24 November 2021

RE: AMENDMENT REPORT FOR SSD-11869481, UPGRADES TO NORTH SYDNEY PUBLIC SCHOOL

## DRAWING STREETScape ELEVATIONS & SCHOOL SIGNAGE

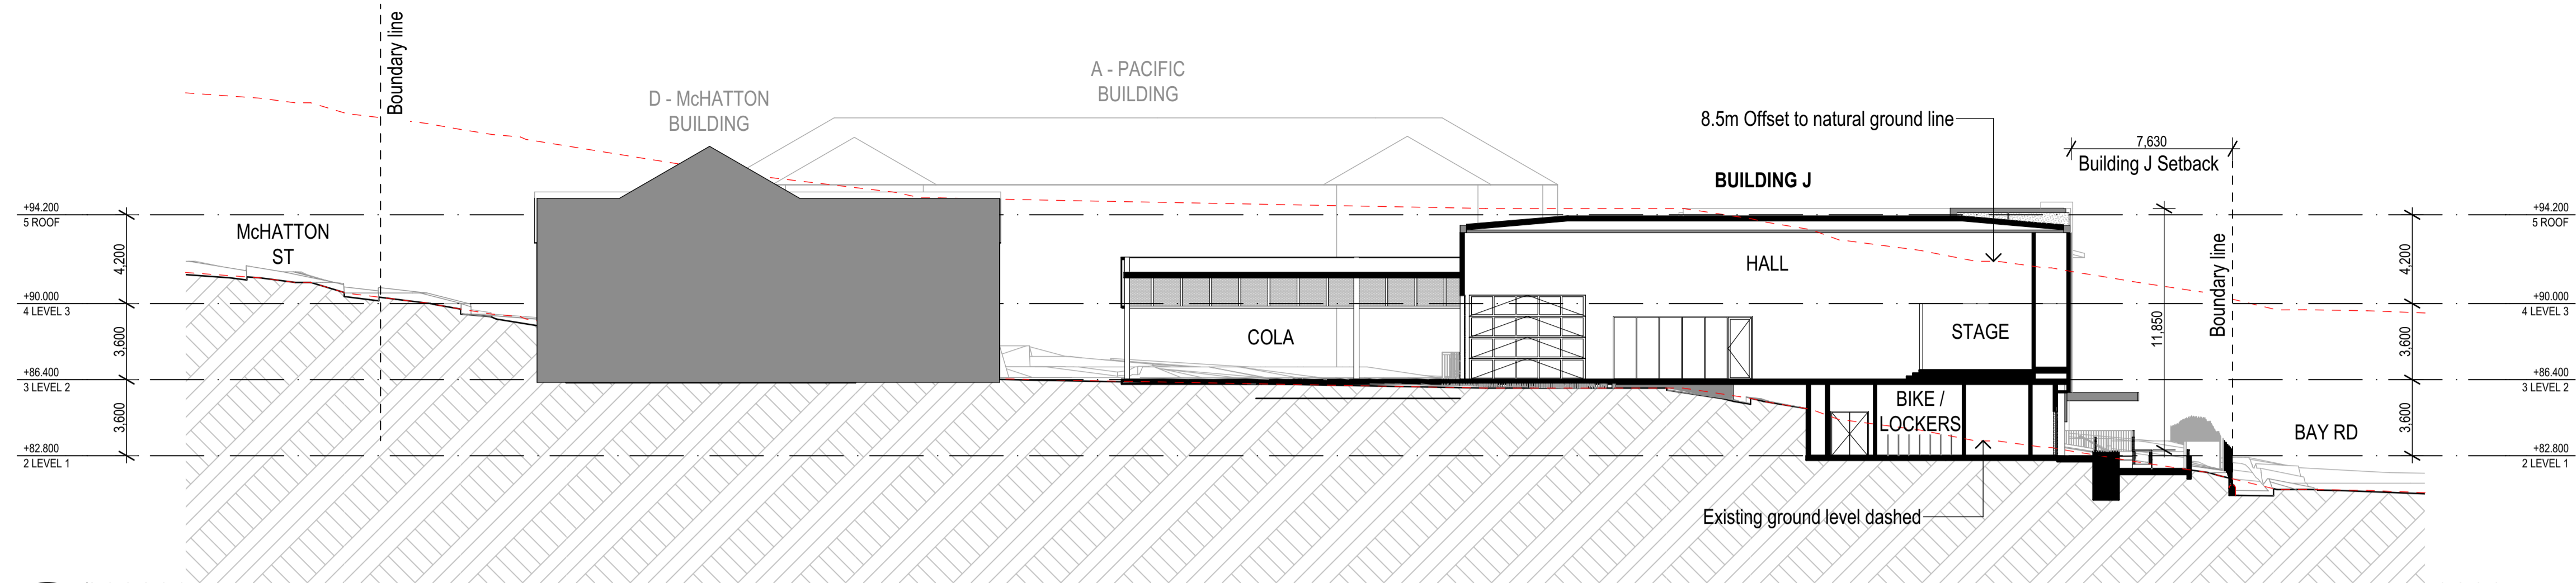
The school identification sign which contains the school logo and words *North Sydney Demonstration School* has been relocated from the southern façade of Building I, to proposed recessed portion of Building J above the entry forecourt. Refer to the following images.

1 ELEVATION  
BUILDING J - SOUTH ELEVATION  
SCALE: 1:100

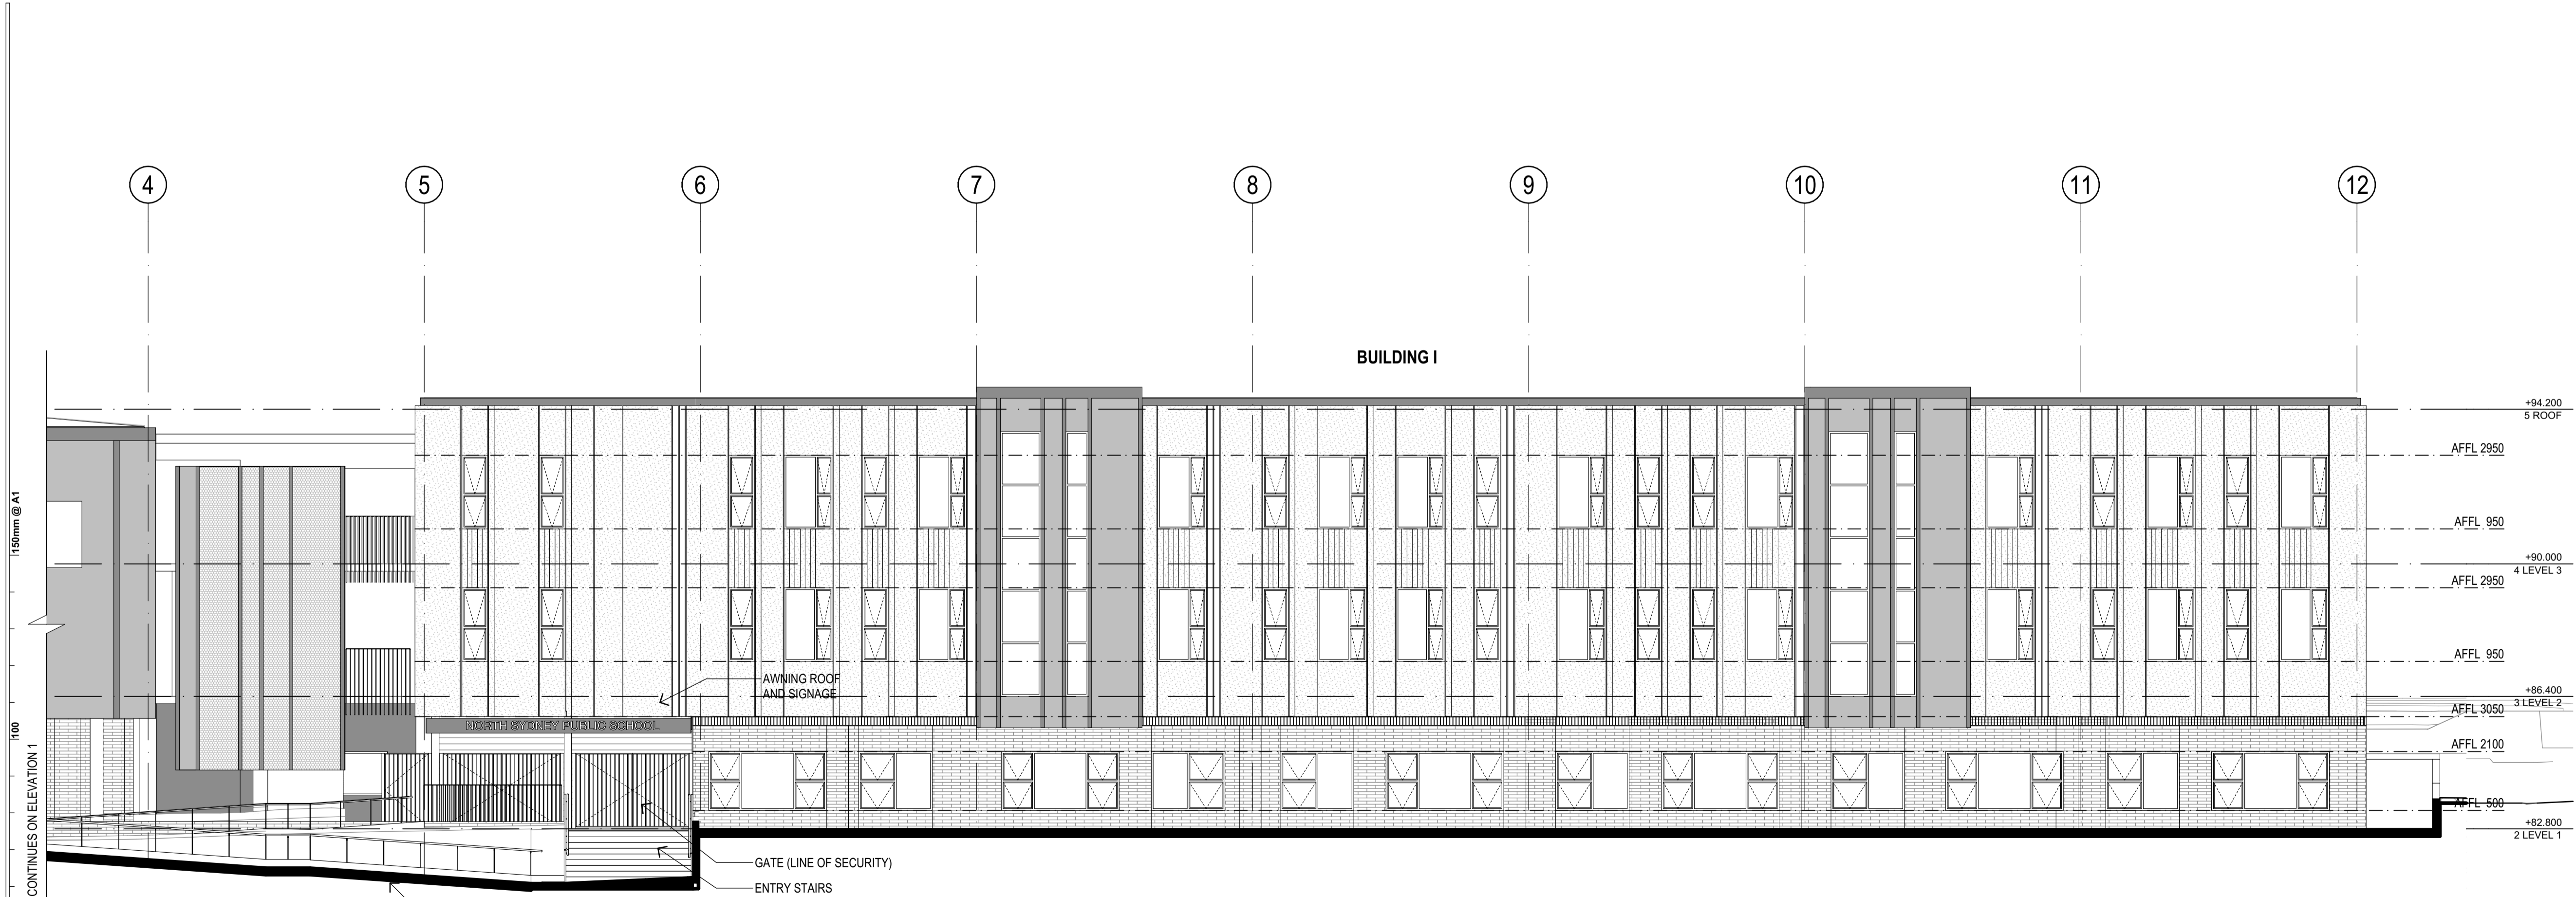
Fulton Trotter has further developed the Bay Road façade treatment and refined the materials and finishes for the proposal, refer to Appendix 2. Changes involve:

- Transition of the glassfibre reinforced concrete (GRC) panelling from large format panels to smaller-scale panels. Refer to Figures 3 and 4.
- The product chosen provides texture finishes with the panelised system. Refer to Figure 3 and 4;
- The depth of the placement of windows within the façade has increased, emphasising the 'punched' nature of the windows and a framing element added to tie the vertical panels of the window in a similar structure of the detailing of the existing brick buildings on the site. Refer to Figure 3 and 4; and
- Alteration to the planning of the buildings above the entry and entry awning to allow the building form to be recessed at this point. Refer to Figures 5- 8.

**2** ELEVATION  
BUILDING J - EAST ELEVATION  
SCALE: 1:100

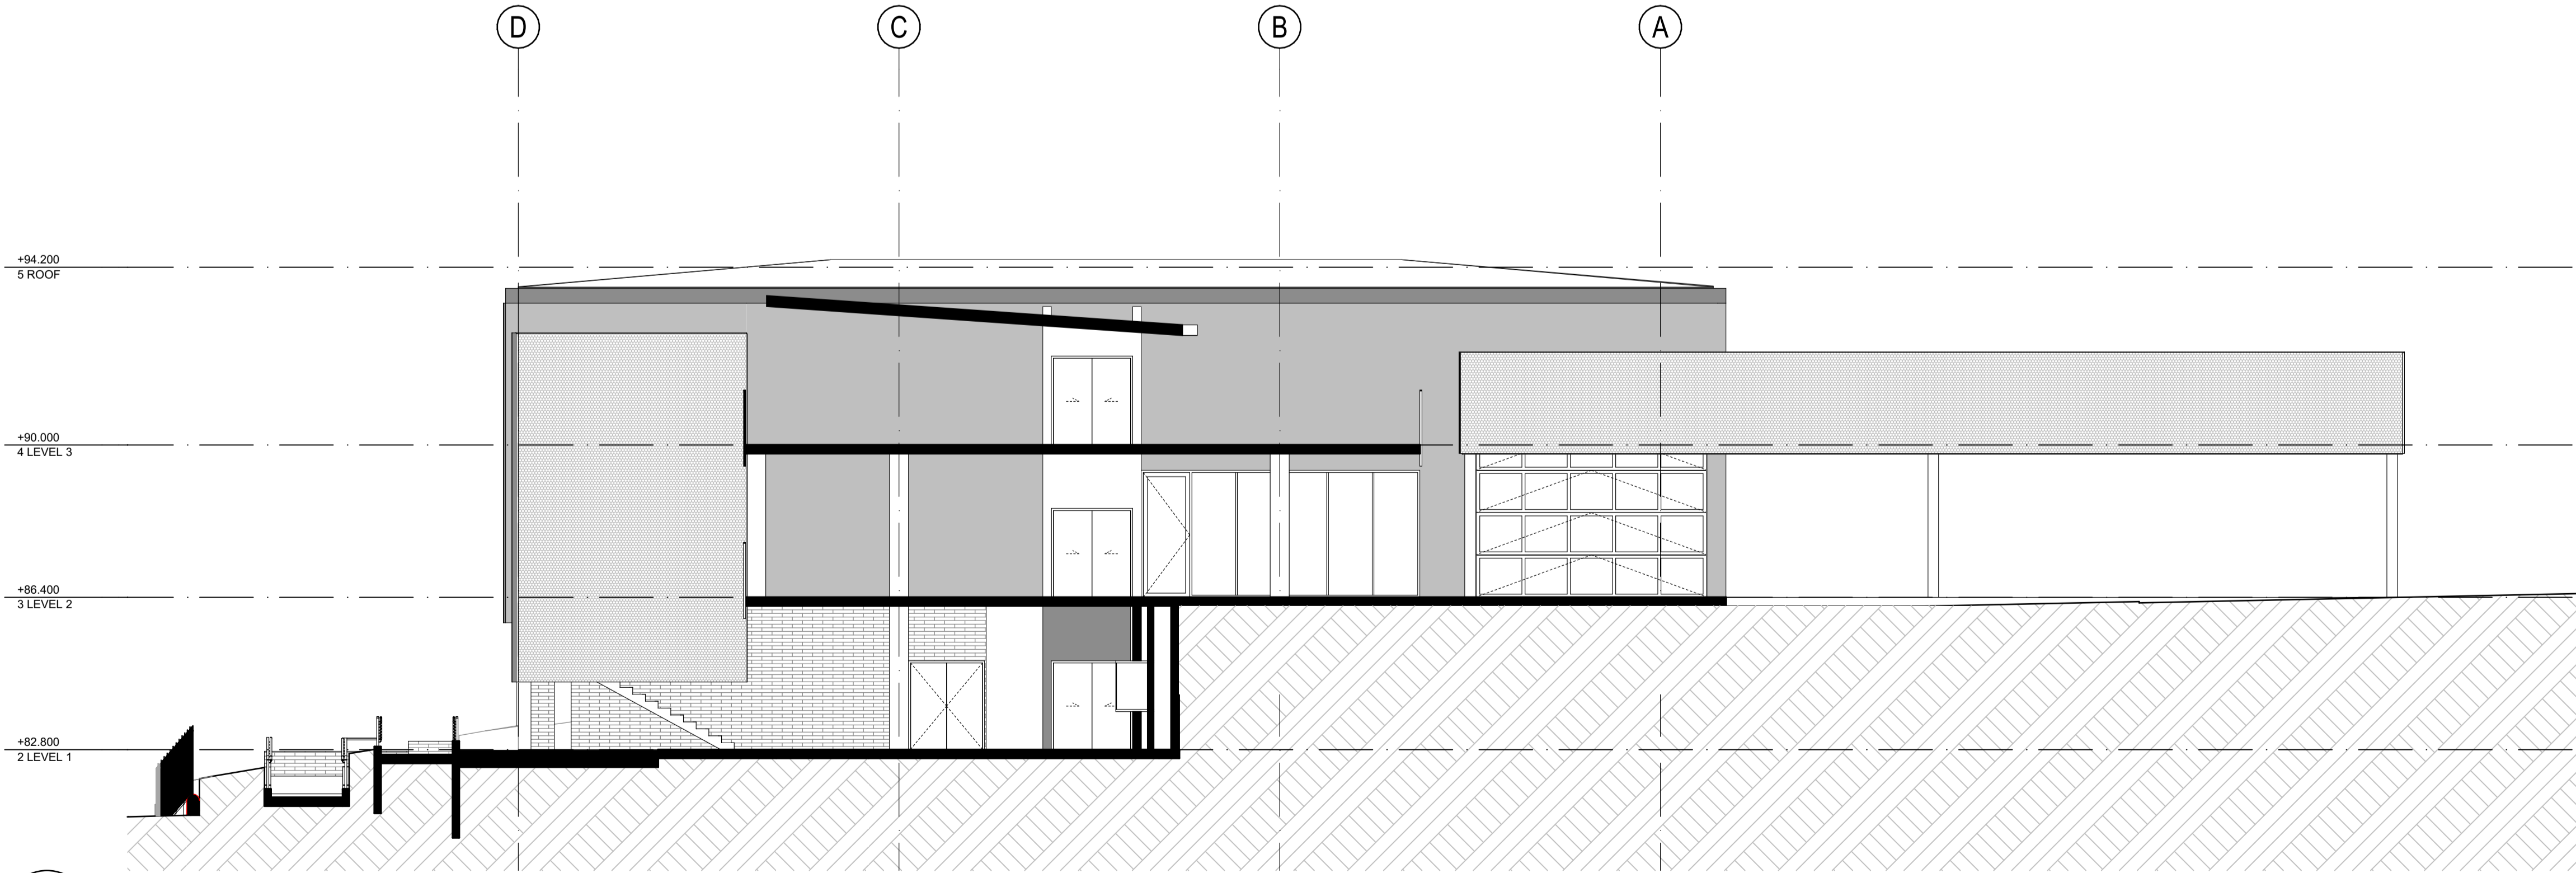
In response to the SDRP feedback, Fulton Trotter has added windows and textured detail to the eastern façade of Building I, see below comparison images.
